**Consultation Response from KC,
Trees**

2026/90702 Fieldhead, Snelsins Road, Cleckheaton, BD19 3UE

Demolition of existing outbuildings and erection of detached leisure building, car port and annex accommodation associated with Fieldhead, Snelsins Road, Cleckheaton, BD19 3UE

Date Responded: 15/04/2026

PROPOSED SITE PLAN

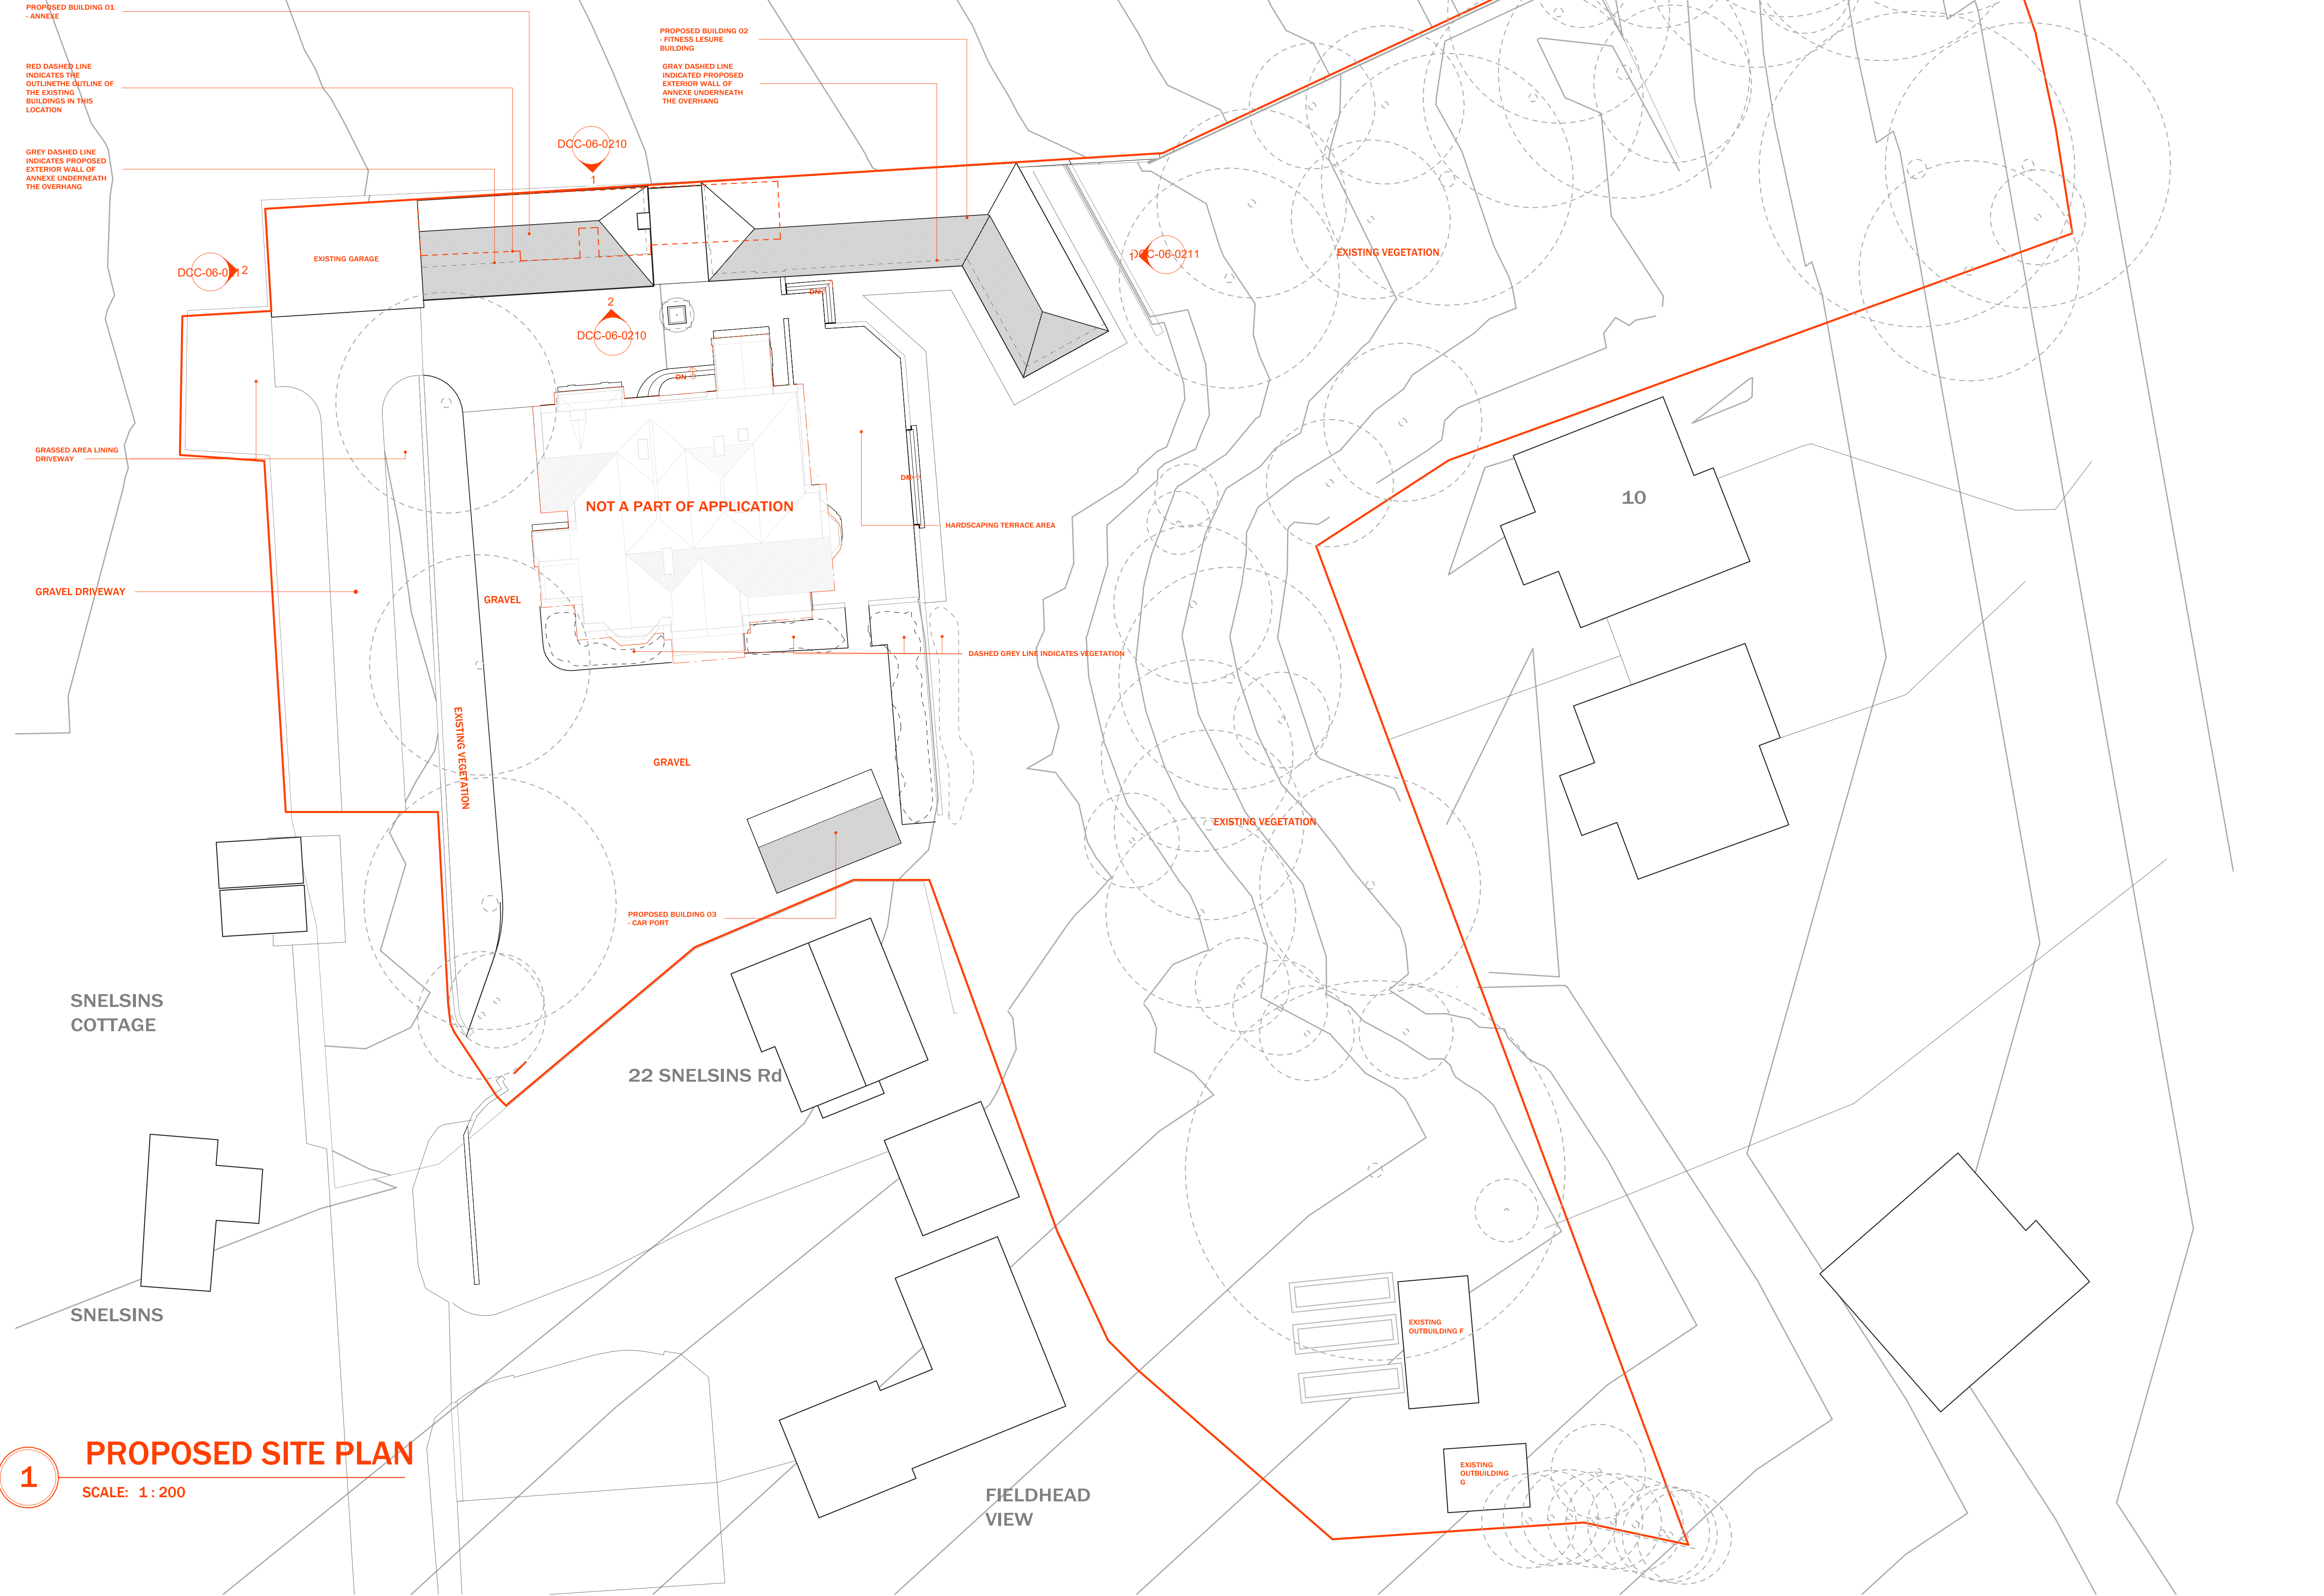
It is understood that the proposed pool house is sited mindfully to avoid the adjacent protected tree. However, for applications to demonstrate that they meet the requirements of Kirklees Local Plan policies, all planning applications, that may affect trees, are supported by the necessary documents set out in British Standard BS 5837, Trees in Relation to Design, Demolition and Construction Recommendations. On that basis the following documents are required in support of planning applications, all of which should be in accordance with BS 5837:

There is a holding objection from an arboricultural perspective. The proposal conflicts with adopted Kirklees local plan policy 33 and 24 (i).
